Arun District Council
Arun Civic Centre
Maltravers Road
Littlehampton
West Sussex BN17 5LF
Planning & Building Control General Enquiries
Tel: (01903) 737756 Fax: (01903) 730442
Dx: 57406 Littlehampton
Minicom: 01903 732765
e-mail: planning@arun.gov.uk
website: www.arun.gov.uk/planning

Application No: K/55/20/PL
Site Address: 57 Coastal Road Kingston BN16 1SN
Description of works: Demolition & erection of 1 No. dwelling. This application is in CIL Zone 4 and is CIL Liable as new dwelling.

Thank you for your internet representation made on 22nd January 2021 which has been recorded as an objection with the comments as follows:

Roof plan

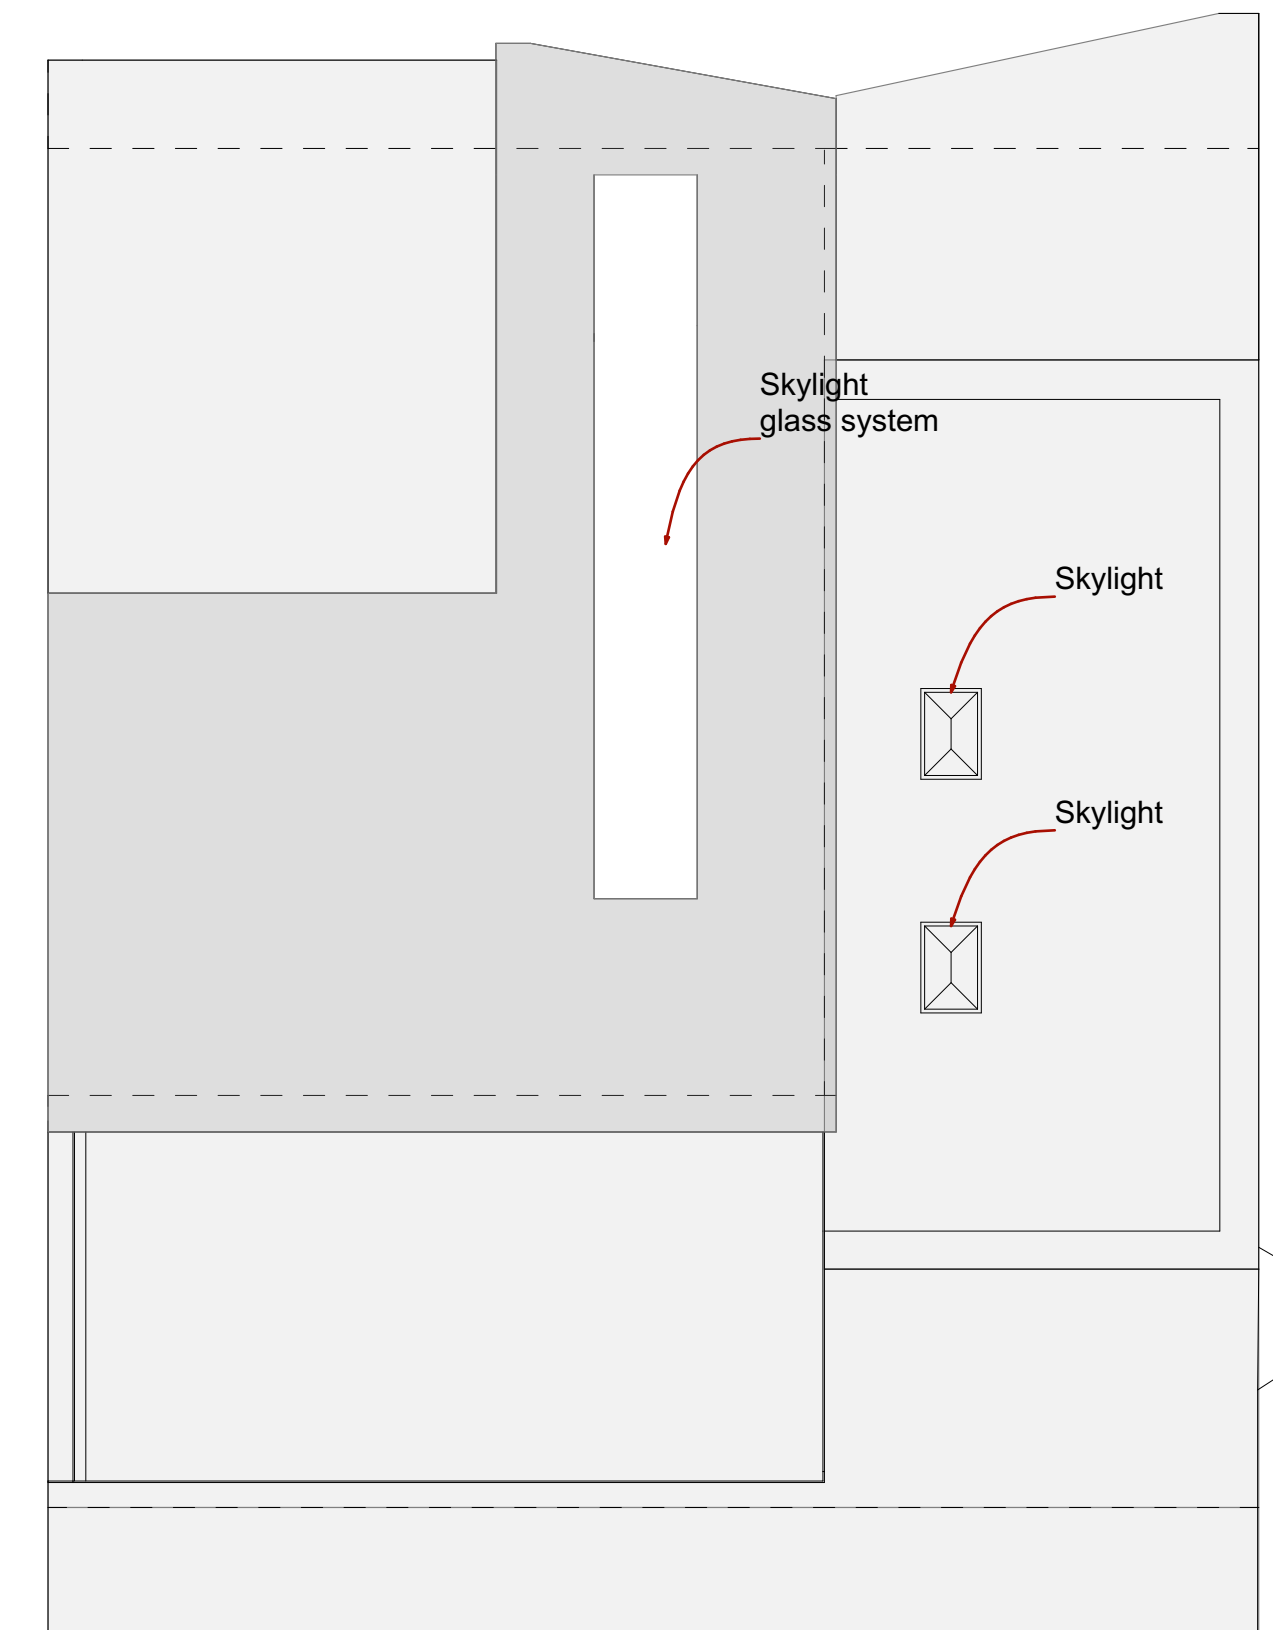
In addition, whilst the drawings do not clearly annotate these, it is understood that there are proposed to be rear terraces at both first and second floor level which is considered will introduce serious levels of overlooking and loss of privacy to the immediate neighbours at no 55 and 59.

Whilst it is recognised that contemporary design has been introduced in the area, the overall design of the proposed dwelling is one which does not complement this part of the Estate and its immediate setting. I believe it is bland and unexceptional in its appearance. Furthermore, the extensive built form by way of massing, three storey scale, excessive height and bulk as well as the wide ranging use of glazing will, in my view, result in a highly unacceptable and inappropriate form of development on this site, which will detract from the pleasant environment as well as harm adjoining residential amenities in terms of loss of sunlight, outlook and the creation of a sense of overbearing and loss of privacy, having regard to the fact that the building footprint is proposed to be extended both to the north and south in comparison with the existing dwelling which itself is already dominant and occupies an appropriate footprint.
